Application number: 2025/91371	
What is the application for?:	Alterations to convert one dwelling to two dwellings (within a Conservation Area
Address of the site or building:	17, Town Gate, Upperthong, Holmfirth, HD9 3UX
Postcode:	HD7 5JN

User comments

Proposed Block Plan

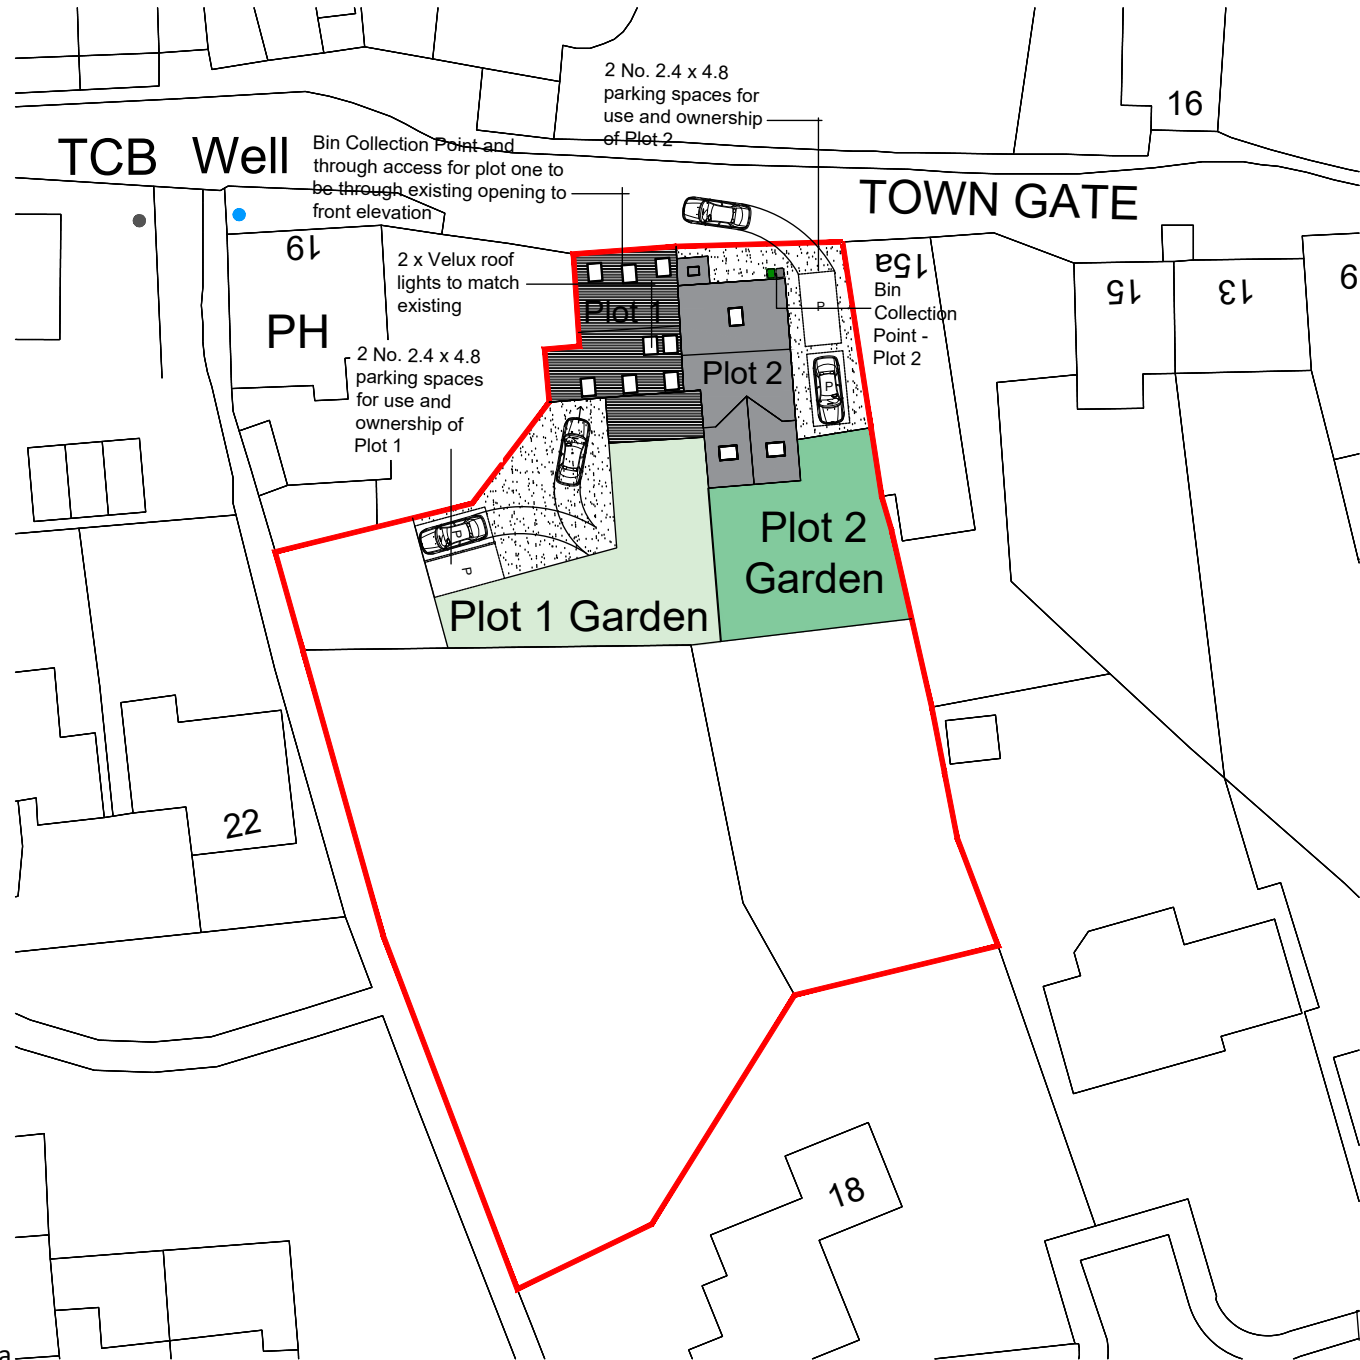
Type of comment: An objection	
Do you wish your comments to be published on the website anonymously?	Yes
Previous approval for one dwelling included the applicant's comments on the unsuitability of the vehicular access on the east side of the property, in order to gain consent for the tunnel to access the rear. However this application for two dwellings clearly show this is no longer an unsuitable parking space for Plot 2 after all? Interestingly all 3 rental tenants to date, of no 17, have not used the proposed parking for 2 cars, choosing instead to park on the road. The swept path diagram for access and exit is very misleading as it does not show the pavement opposite or the likelihood of any parked vehicles. Similarly the same applies for the access and exit of vehicles for the proposed tunnel to the rear of Plot 1. This application will only add further congestion and additional car parking on Towngate and I urge the planning department to revisit the drawings supplied beforehand and currently. This will clearly demonstrate the absence of the pavement and inevitable parked vehicles in an accurately drawn plan.
